AW/53/20/L

The building which is subject to this consent is a Grade II Listed Building. It is also located within the Aldwick Road Area of Character, which is a non-designated heritage asset.

The proposal relates to the replacement of 5 windows on one elevation of the building. At present, there are two window types with the windows to the left of the chimney being different to those on the right. The windows on the left of the chimney are top hung single casement window, whilst those to the right are side hung double casement windows.

Drawing
SOUTH Elevation

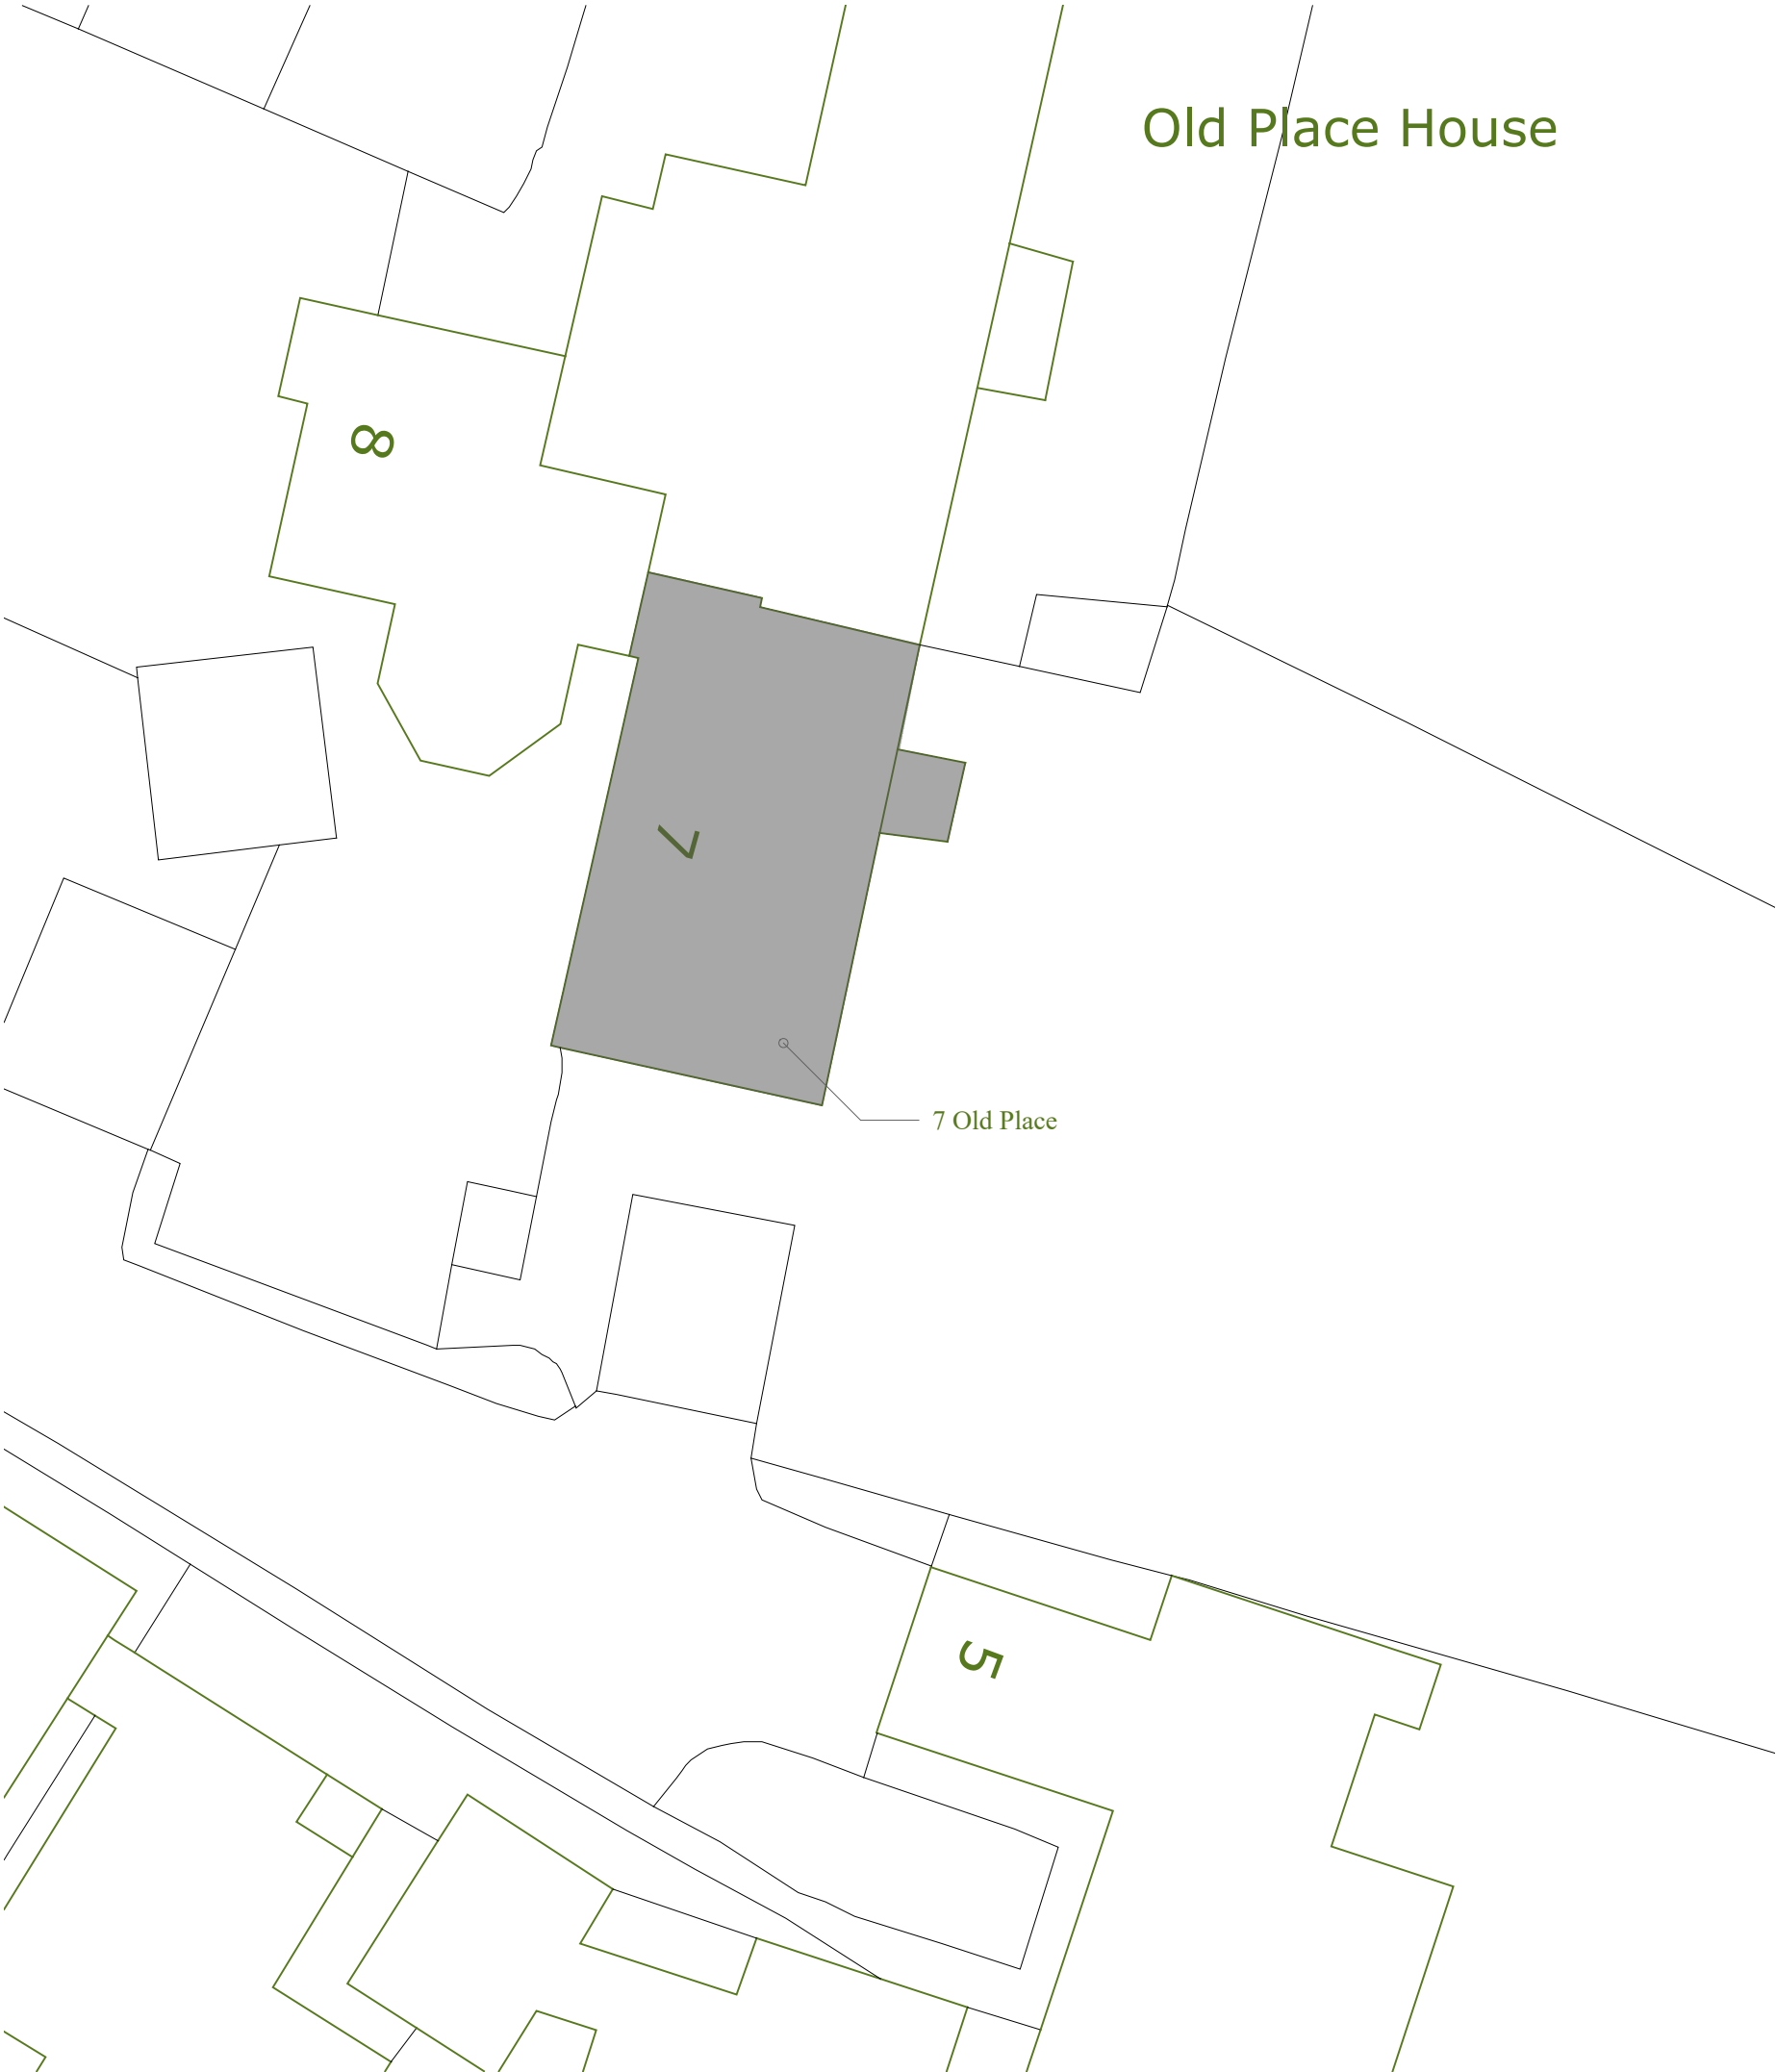
All of the windows will be replaced on a like for like basis with regards to their sections and glazing, but all of the windows will be side hung double casement windows.

It is considered that the proposal is acceptable and will not cause harm to the significance of the Listed Building. As a consequence, it should be determined in accordance with the relevant policies within the Development Plan, along with these comments.

PROPOSED WINDOW DETAILS (windows 1-5)
(EXISTING WINDOW DETAILS (windows 4-5))

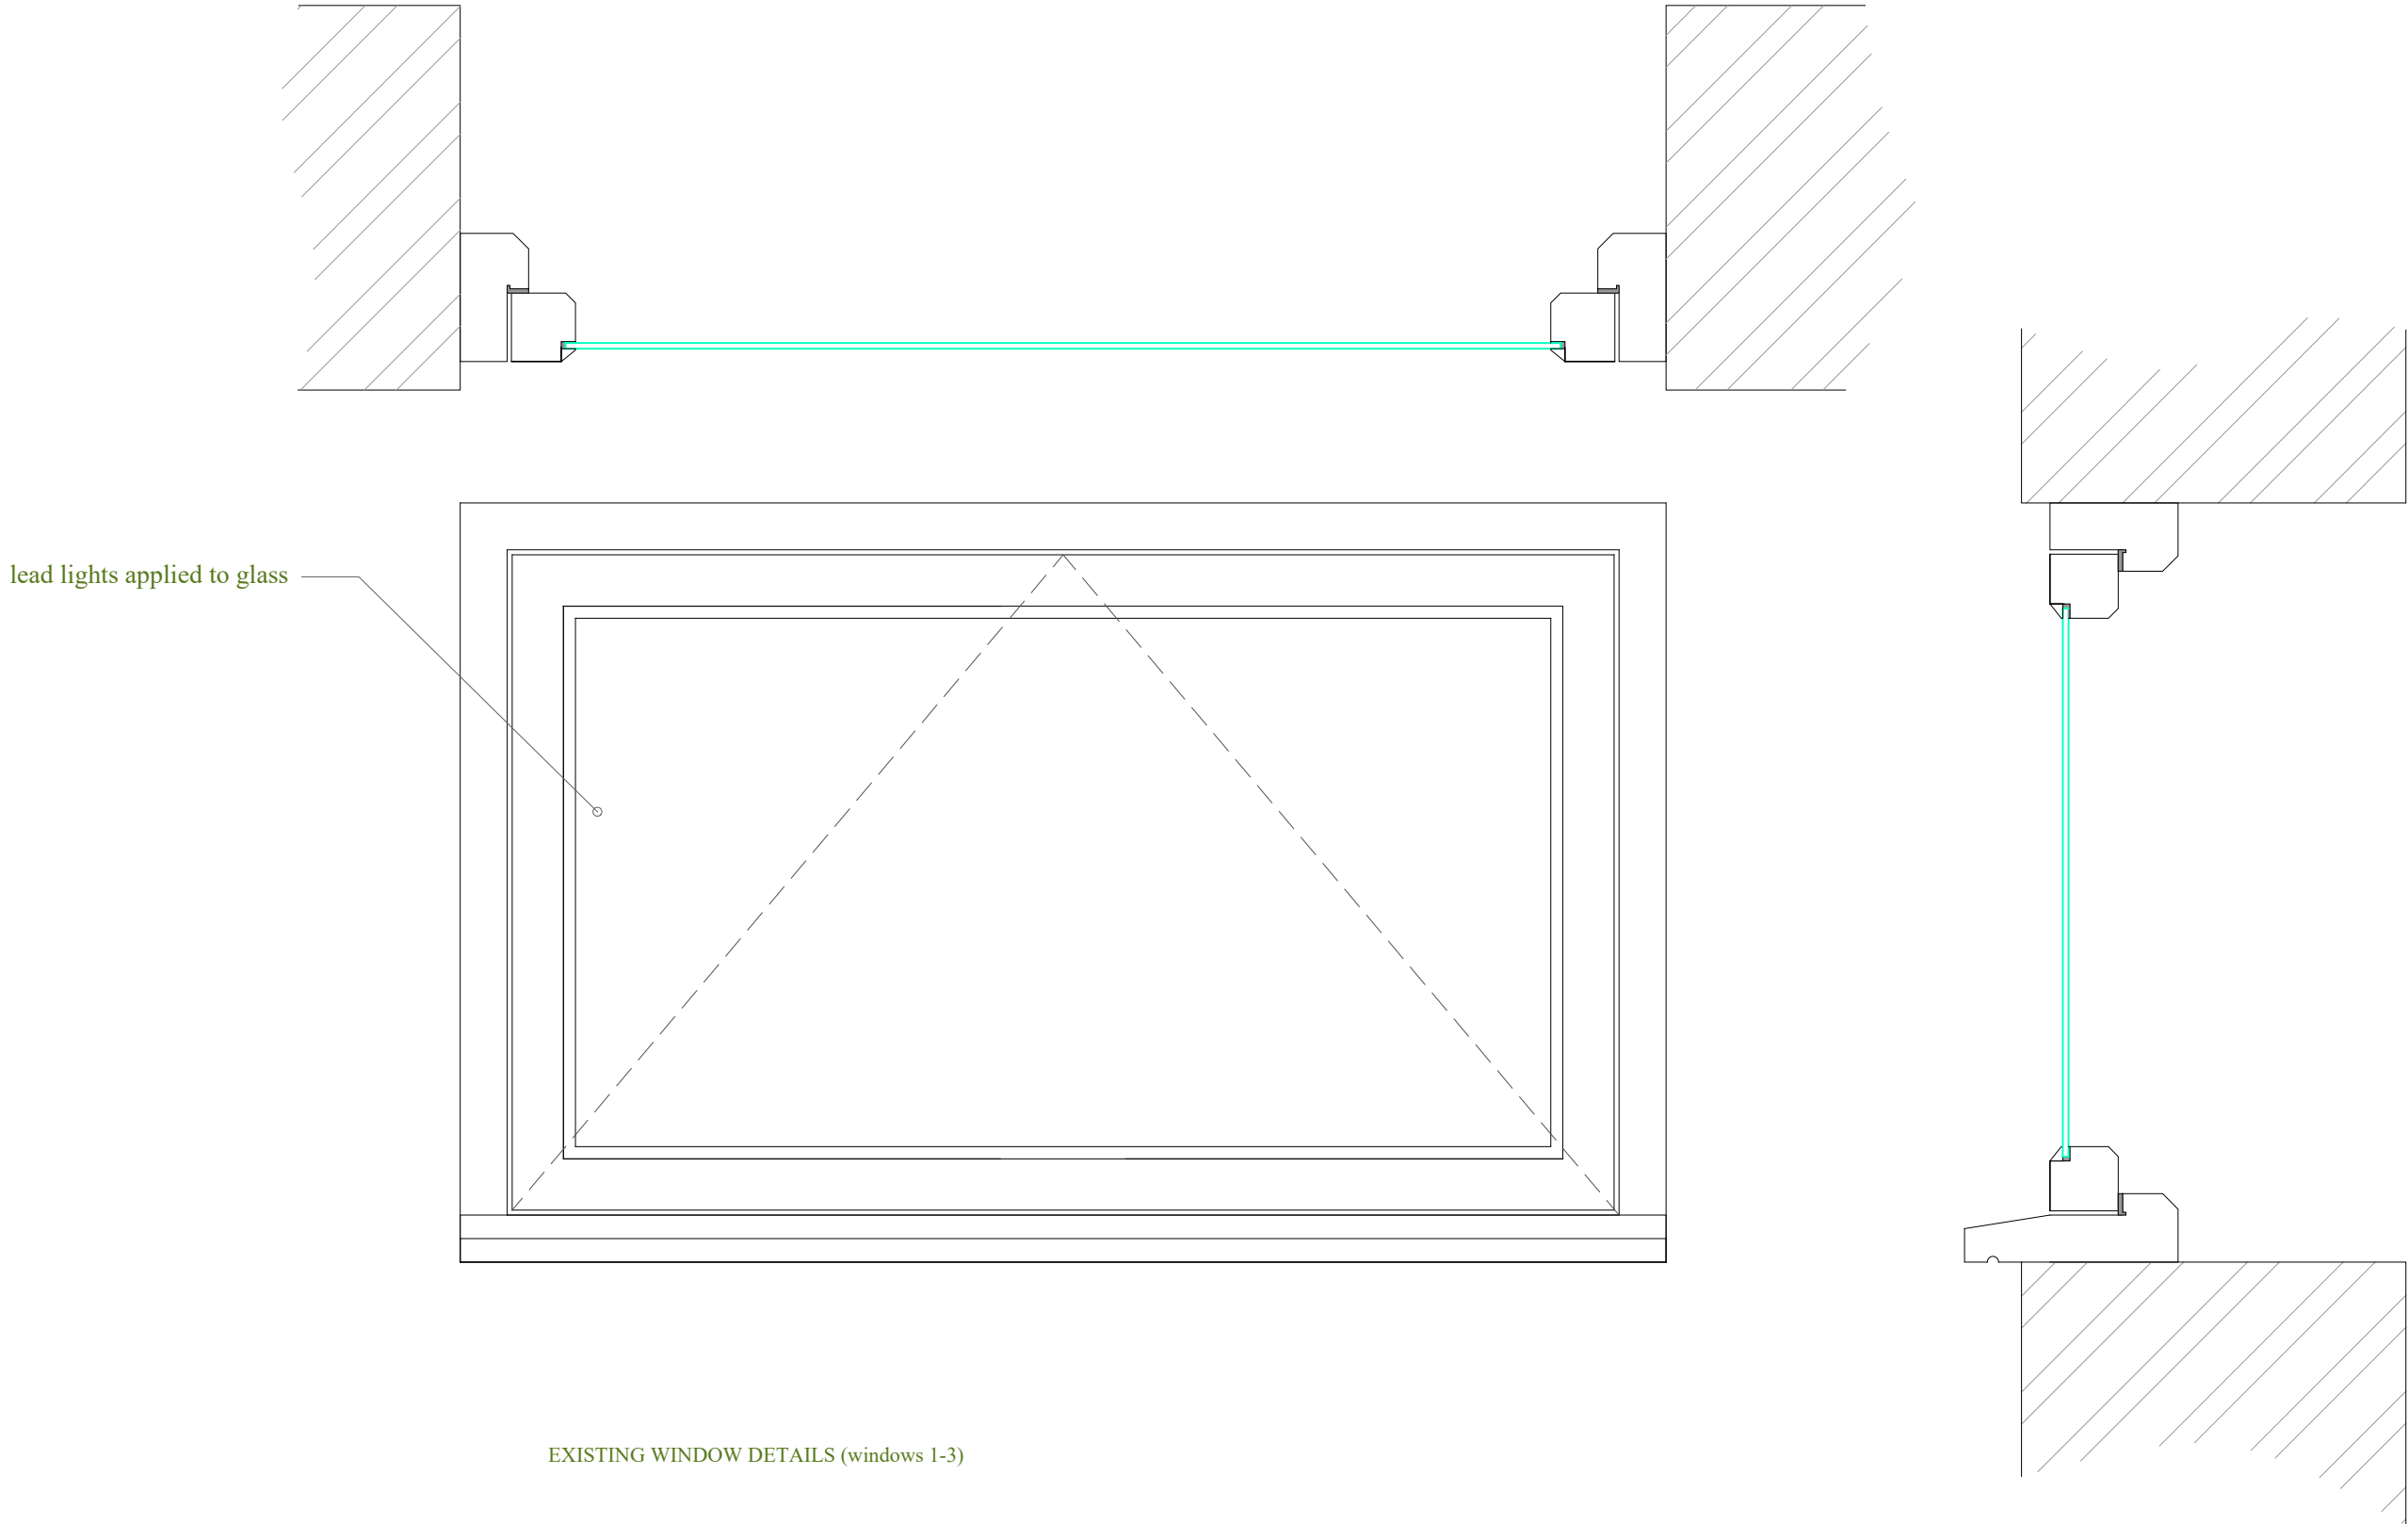
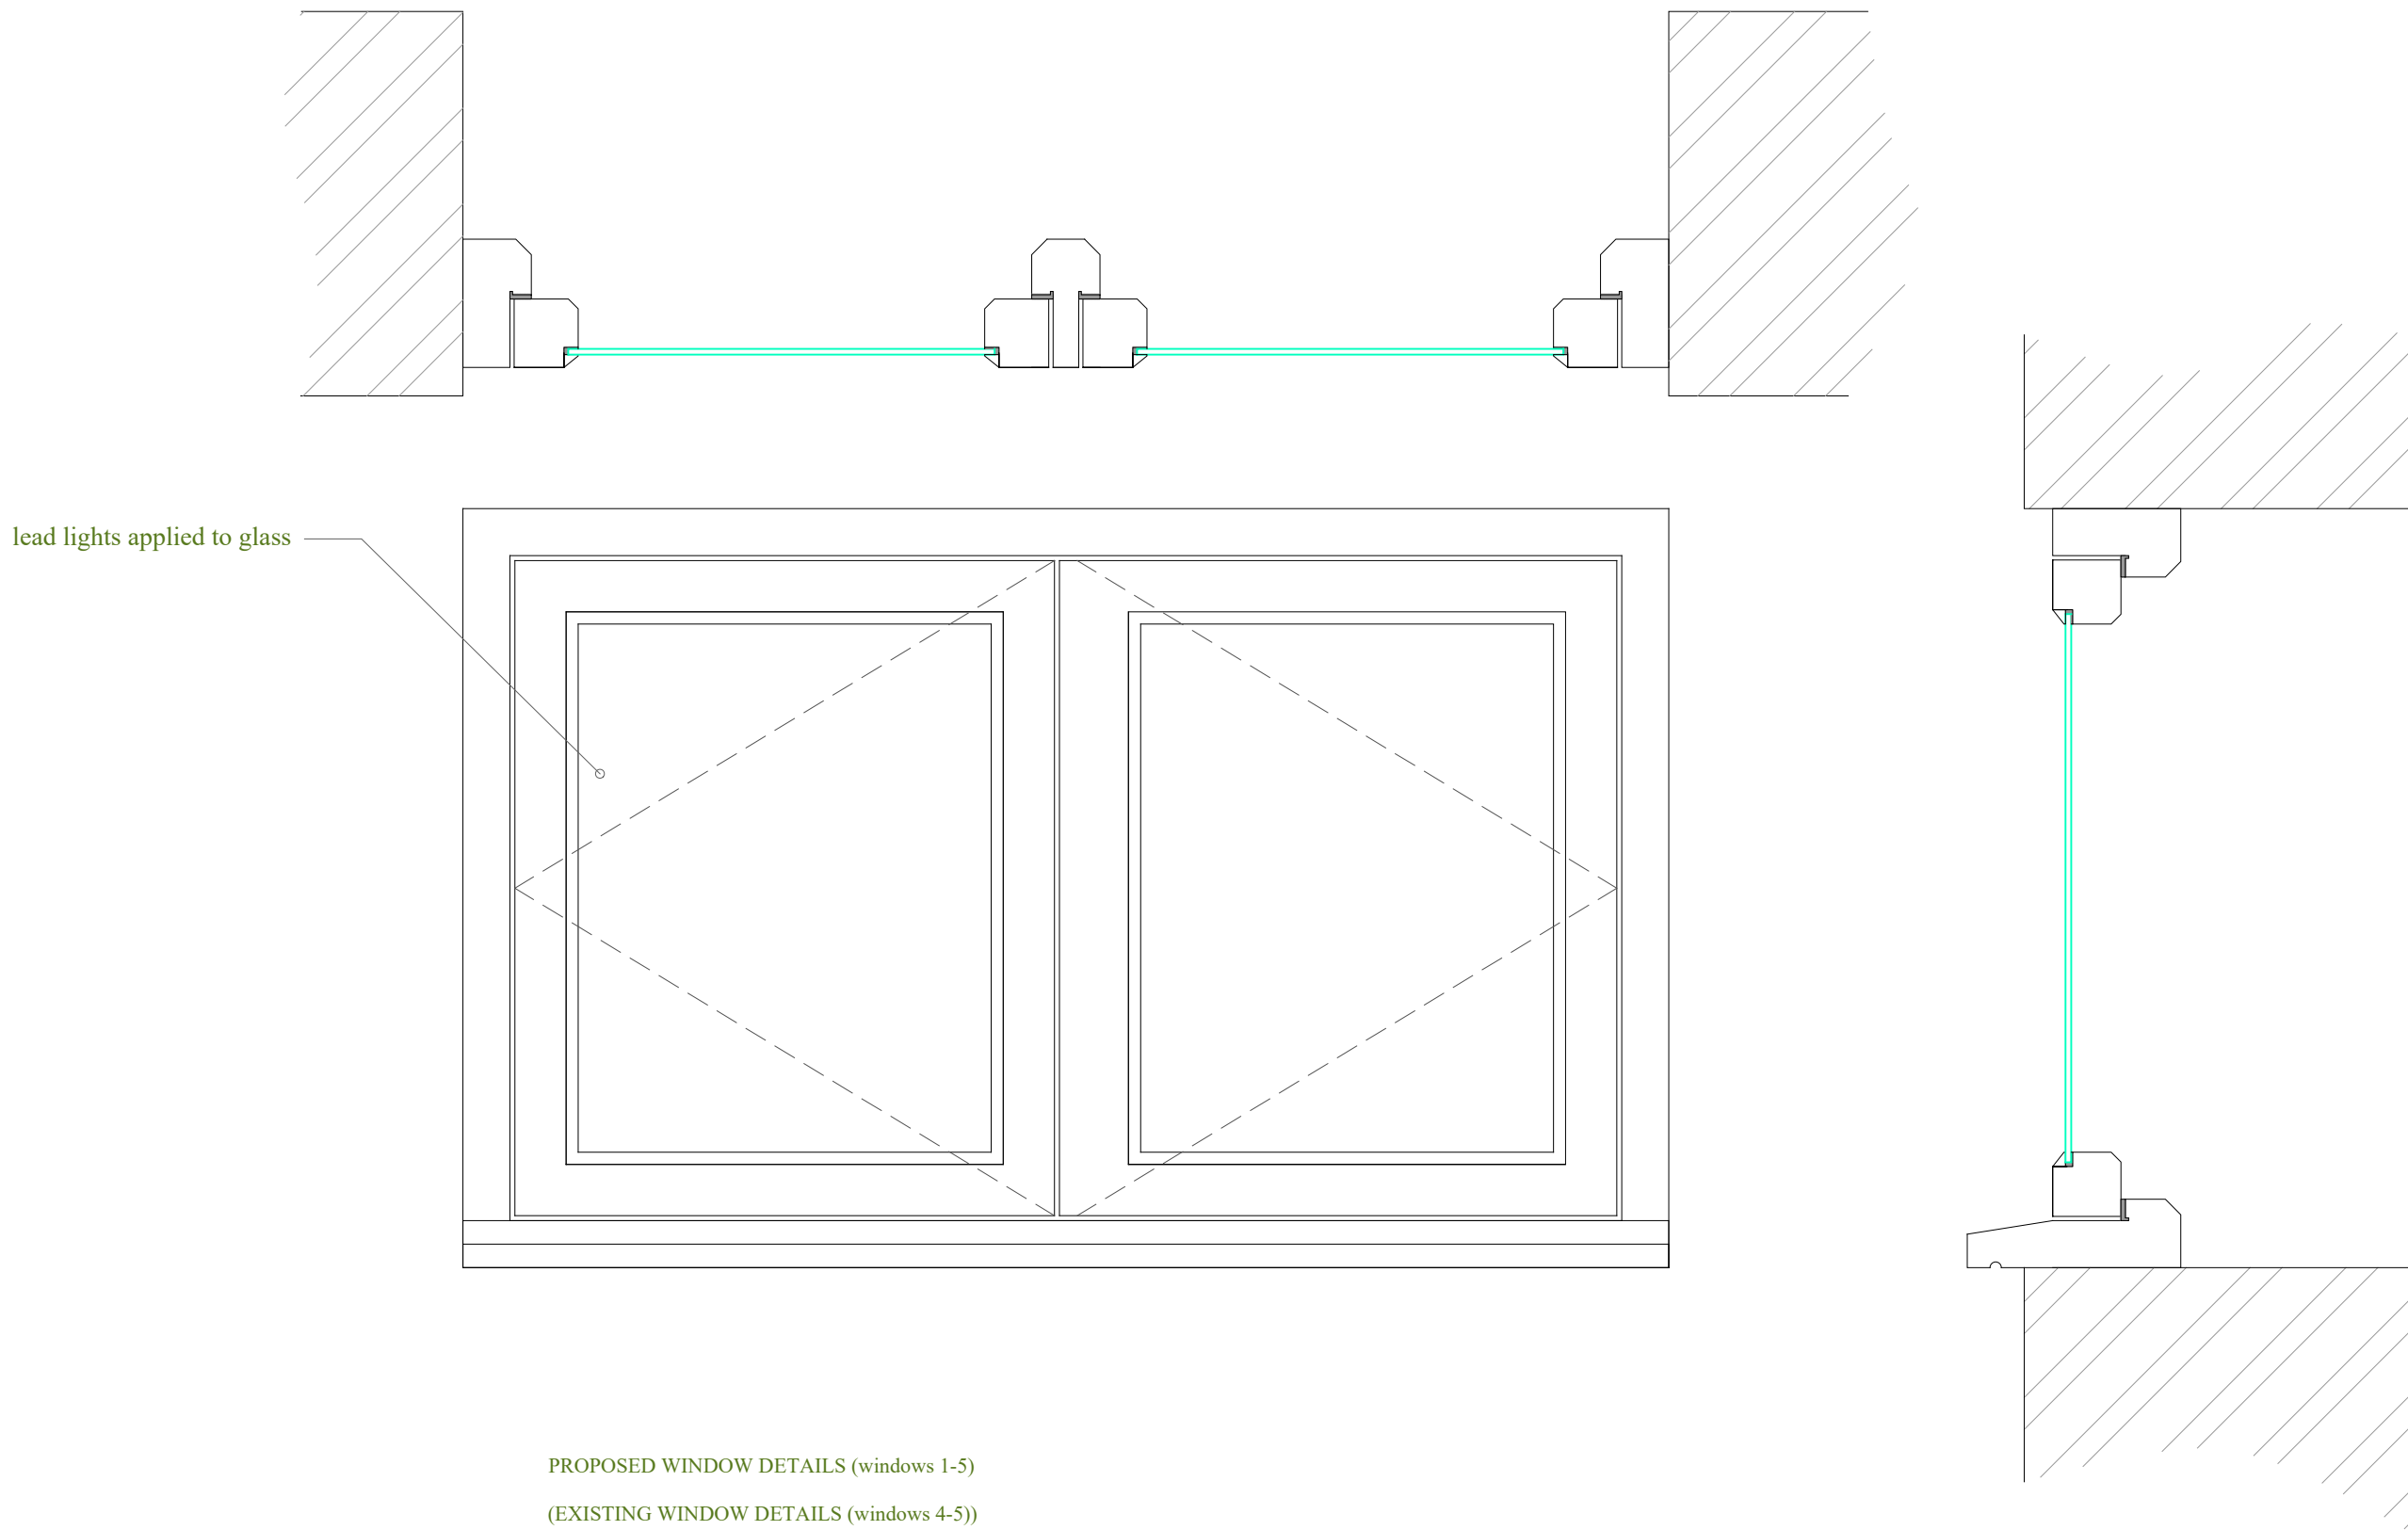
It is noted in the heritage statement that the windows will be single glazed with lead to match the existing. They will also be painted with black frames and white casements to match the existing.
